Meadow High School – App Ref 3348/APP/2020/1589

Further to your comments on the drainage strategy AKSWard would make the following comments and discussion points. We have separated the items for ease.

AKSWard
Surface Water Discharge Point
09.09.20

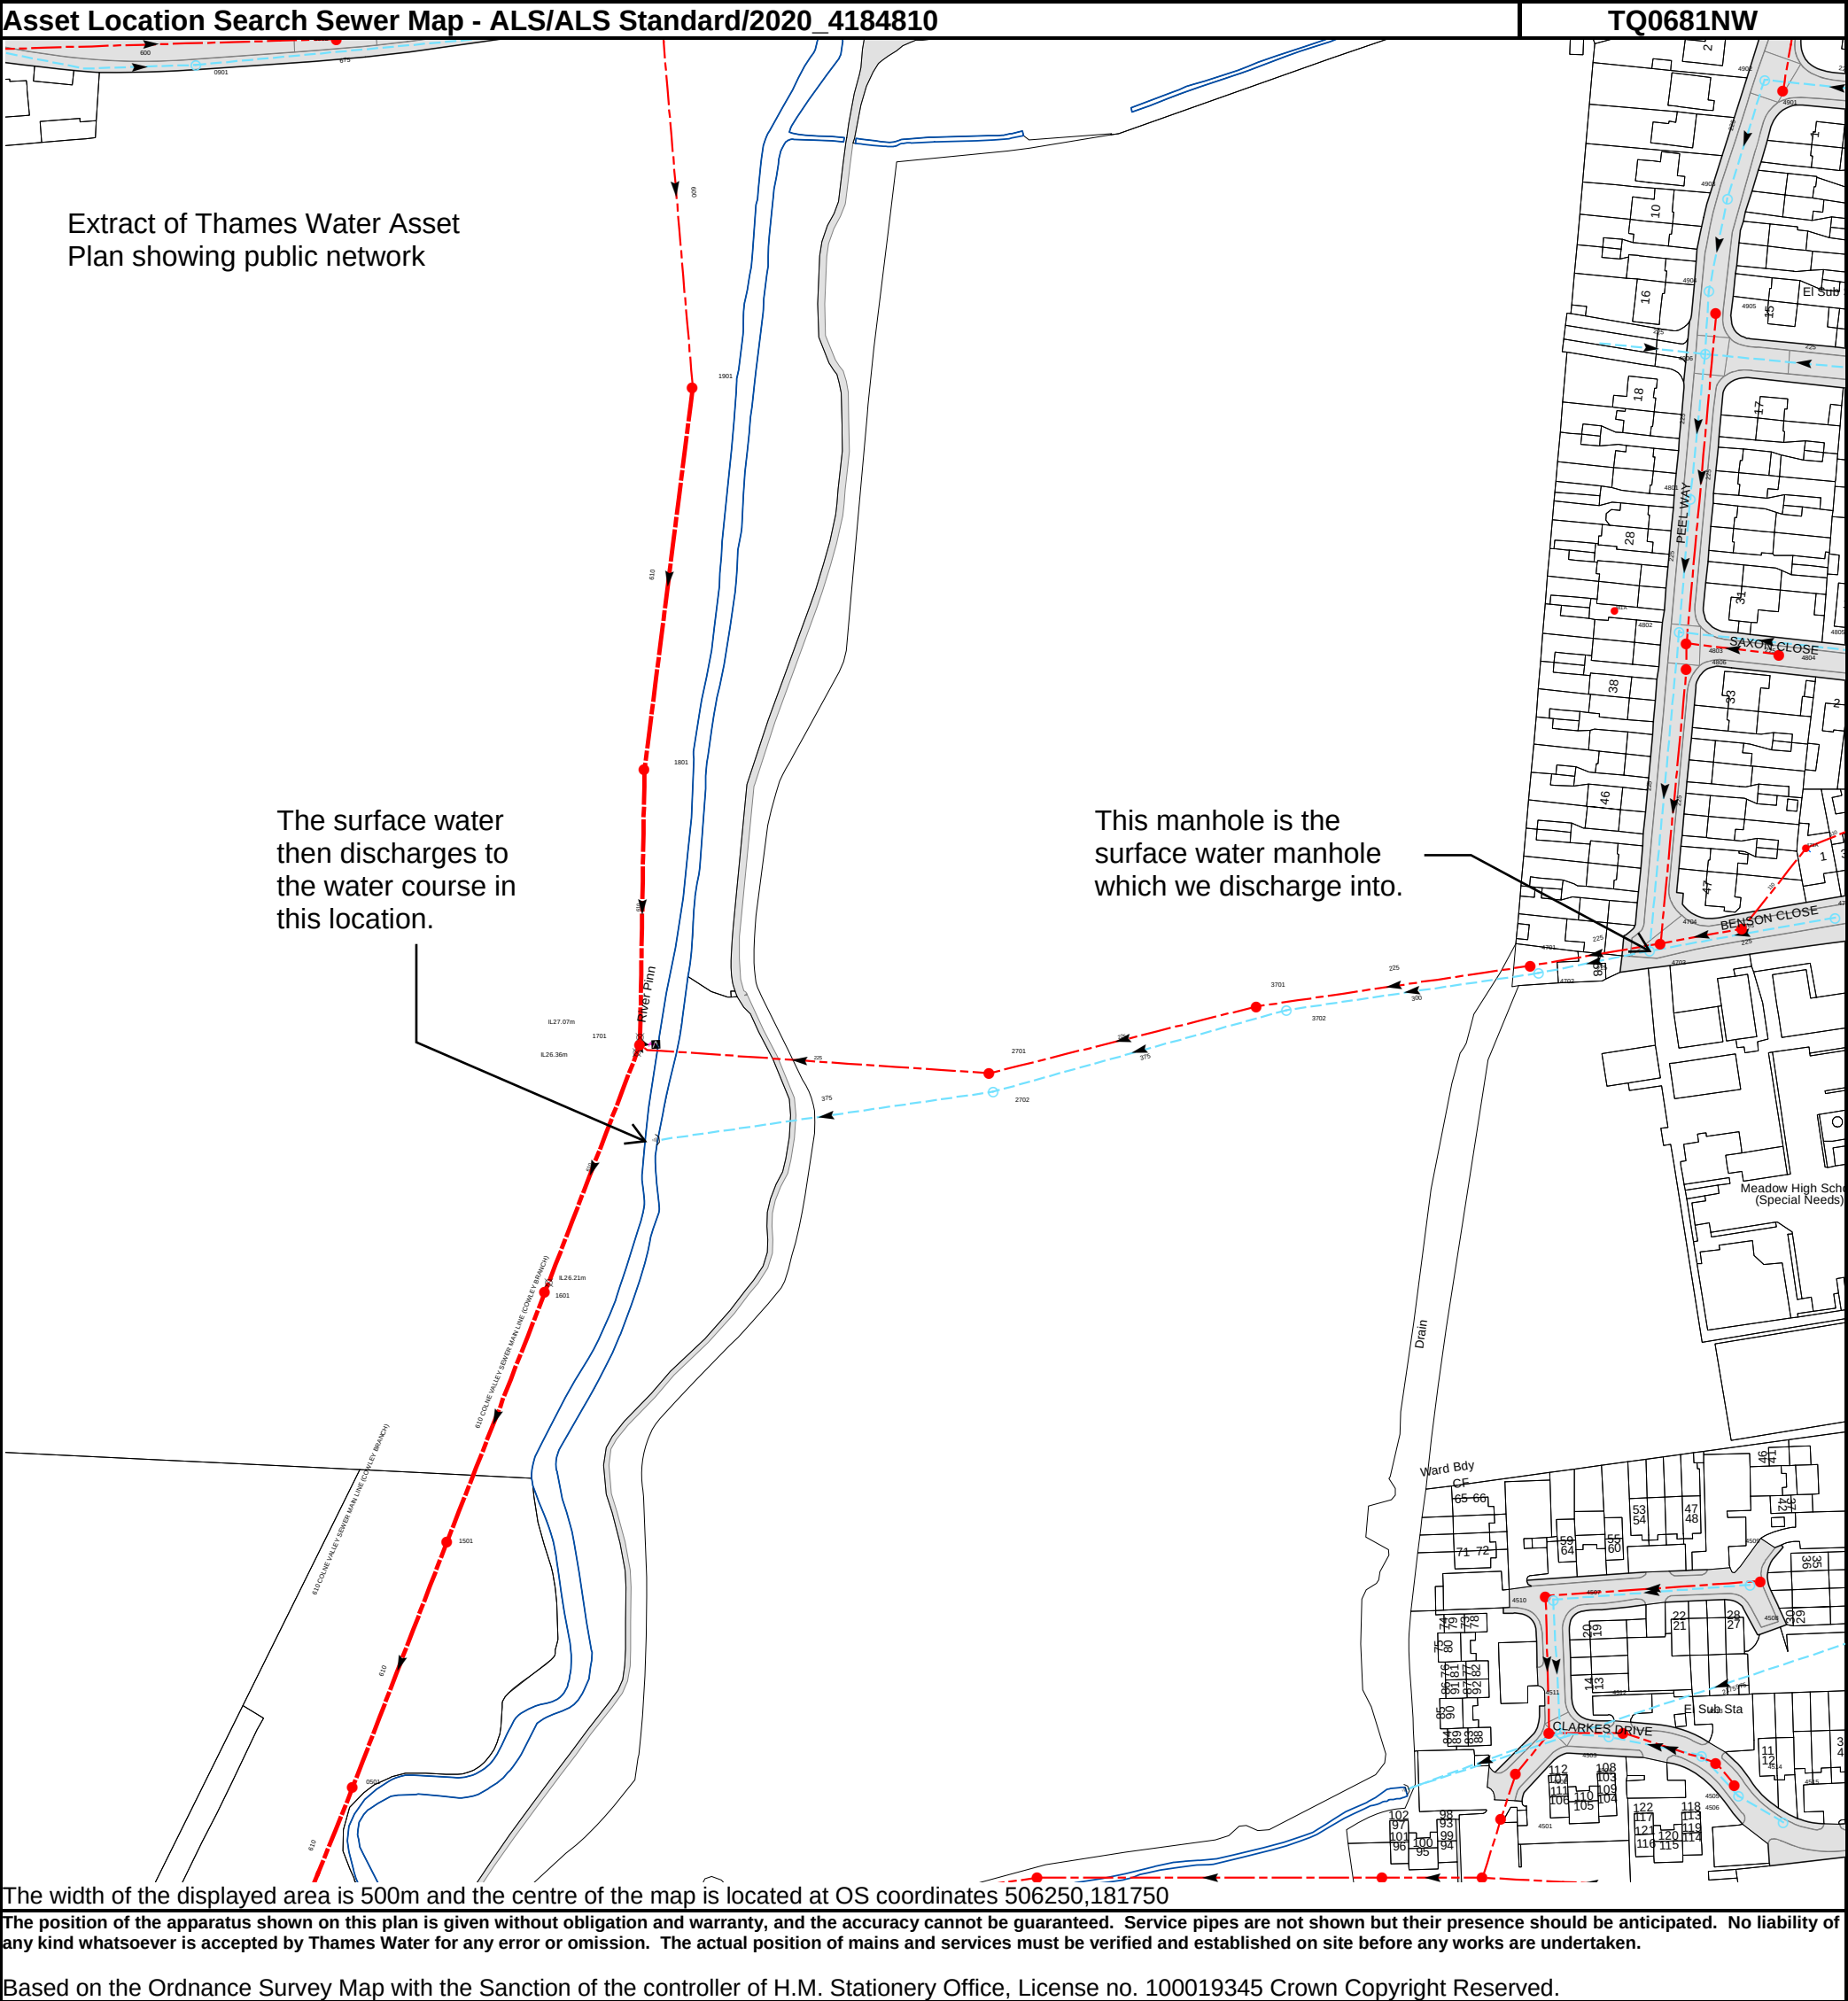
Comment: The surface water should discharge directly to the water course:

Response: The owner of the land between the watercourse and the site has declared that they would not accept a pipe passing across their land. The public surface water sewer which is proposed to be connected into discharges directly into the water course. This is noted on the appended sketch.
